**Town of Addison
Summary of Engineering Revision Comments**

Development: Galaxy FBO

Town Project #:19-09D

Town of Addison Engineering Review Conditional Civil Approval

SHEET NUMBER
C08.01

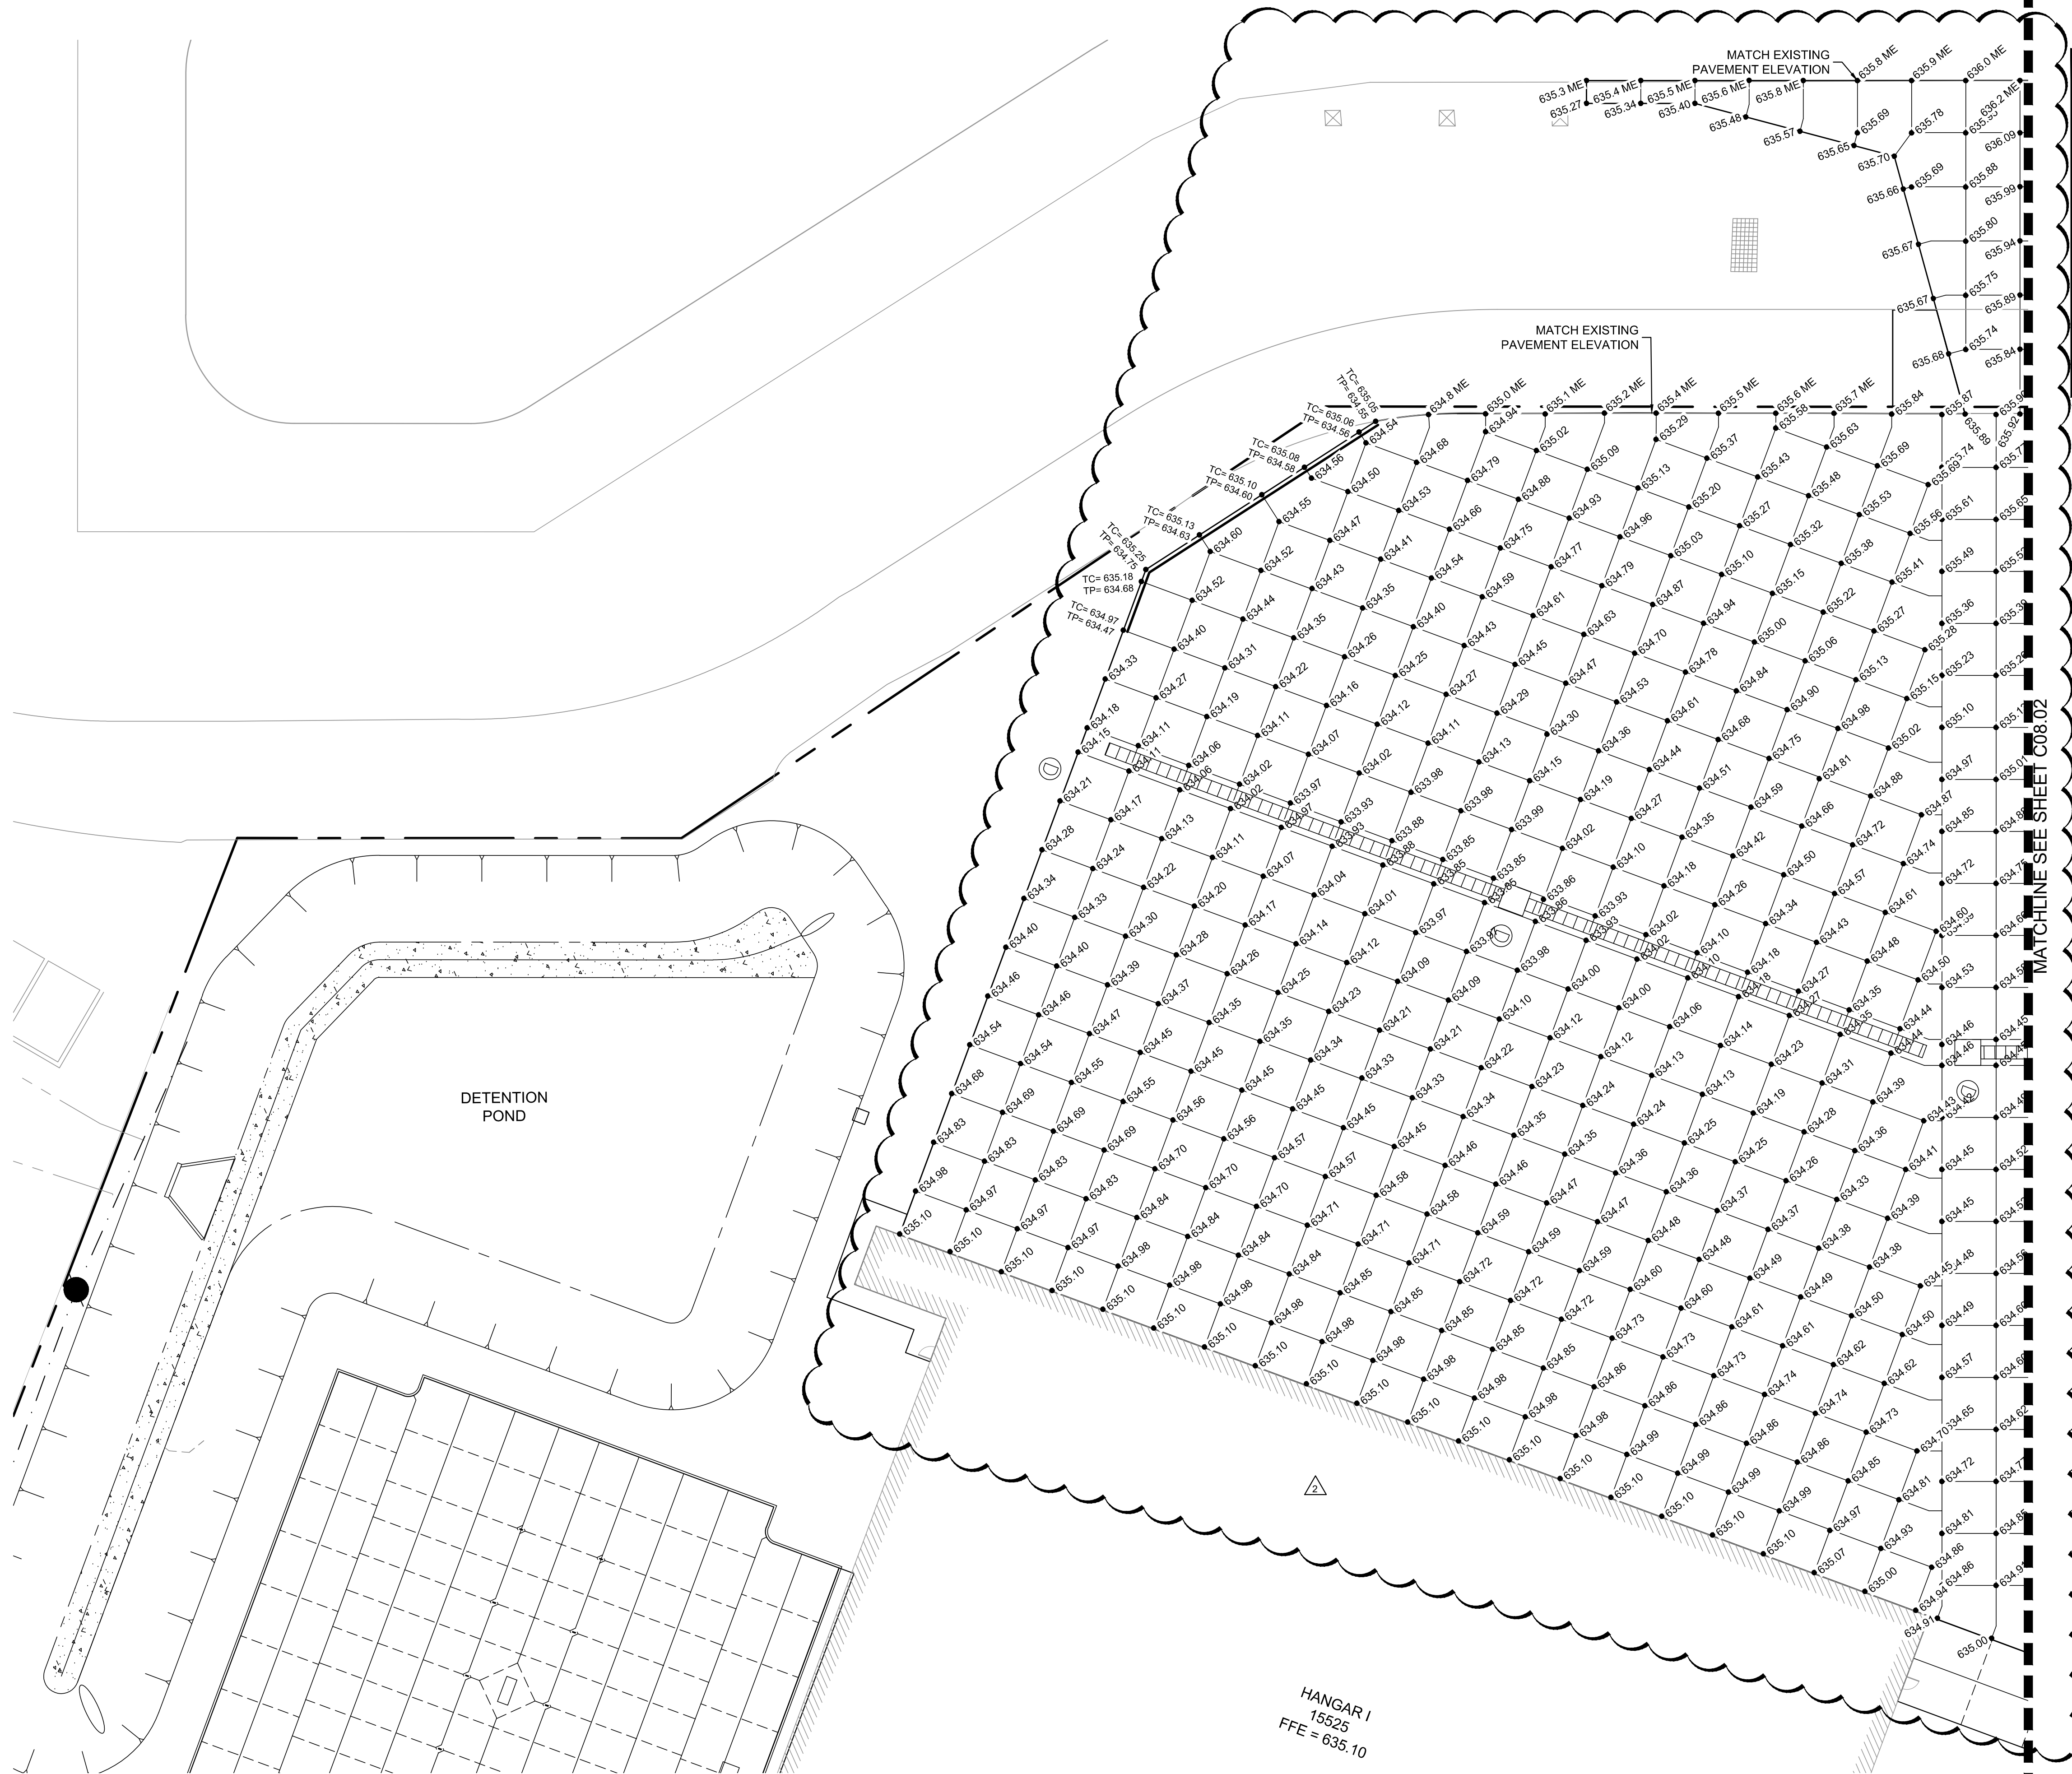
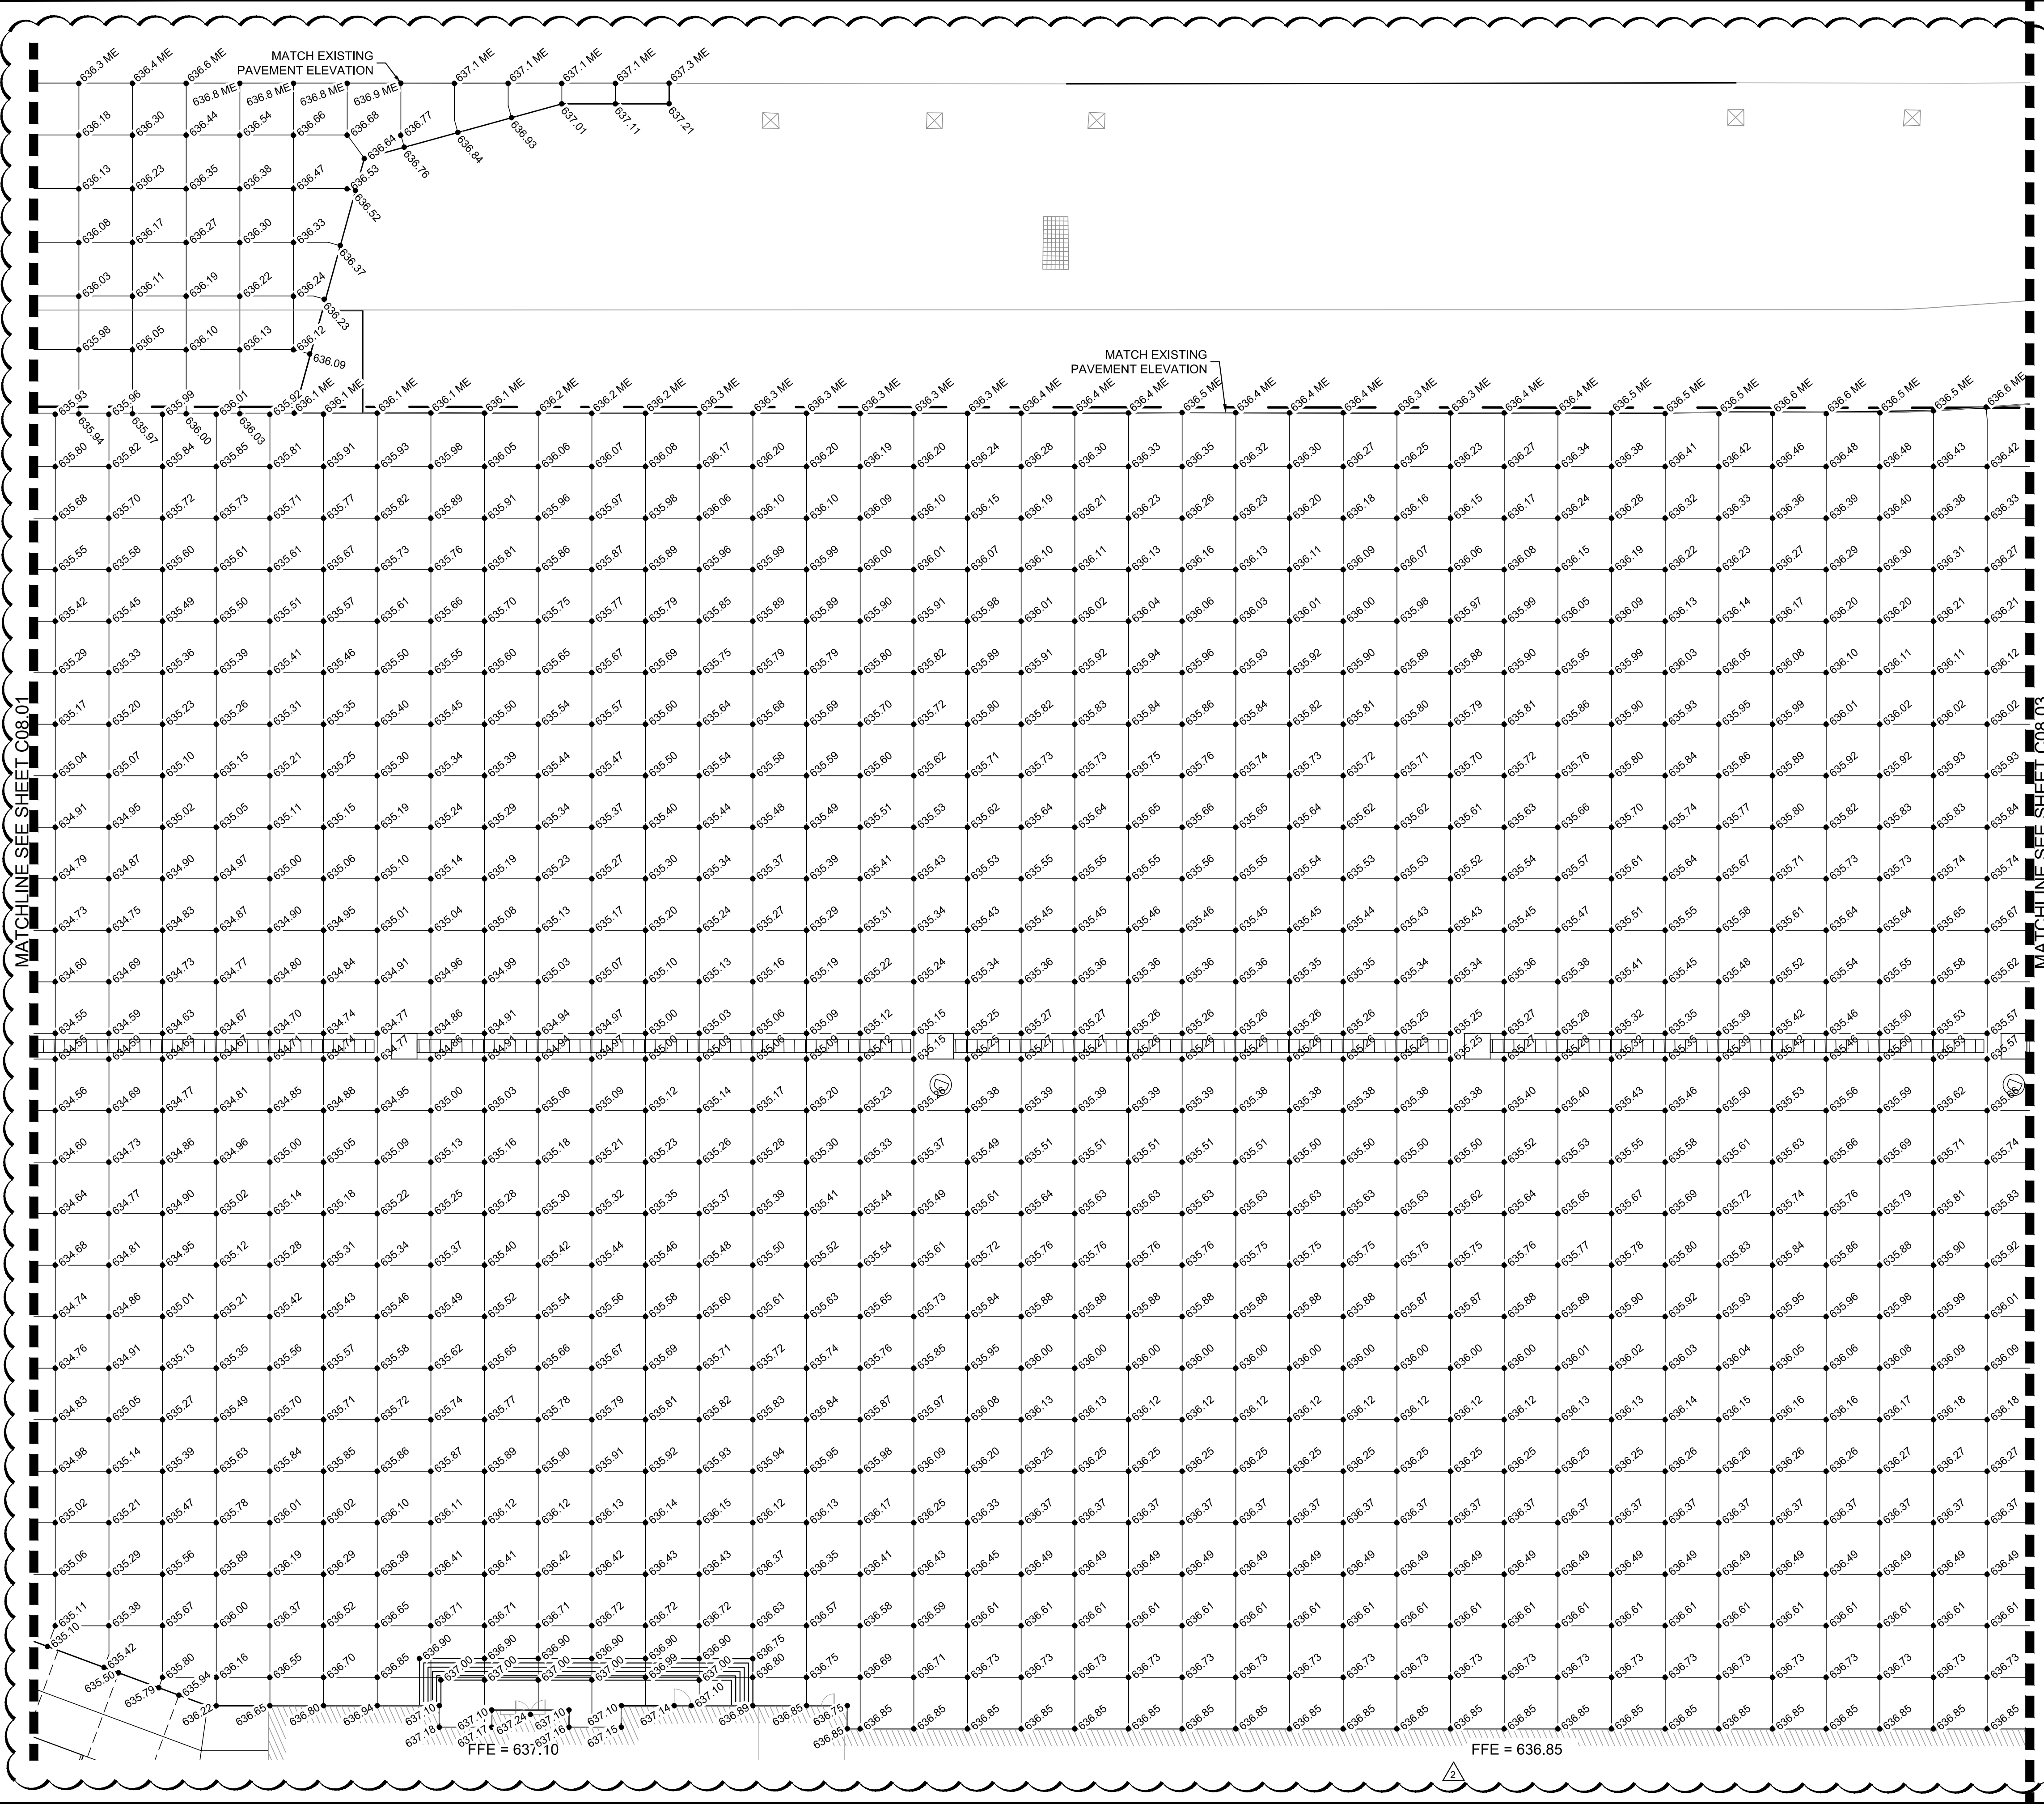
ASI-C006	10/30/2020	C08.01	Updated grading per field conditions verified by a construction progress topographic survey.	
ASI-C006	10/30/2020	C08.02	Updated grading per field conditions verified by a construction progress topographic survey.	
ASI-C006	10/30/2020	C08.03	Updated grading per field conditions verified by a construction progress topographic survey.	
ASI-C006	10/30/2020	C09.01	Updated grading per field conditions verified by a construction progress topographic survey.	
ASI-C006	10/30/2020	C09.02	Updated grading per field conditions verified by a construction progress topographic survey.	
ASI-C006	10/30/2020	C09.03	Updated grading per field conditions verified by a construction progress topographic survey.	
ASI-C006	10/30/2020	C10.02	Updated grading per field conditions verified by a construction progress topographic survey.	
ASI-C006	10/30/2020	C10.03	Updated grading per field conditions verified by a construction progress topographic survey.
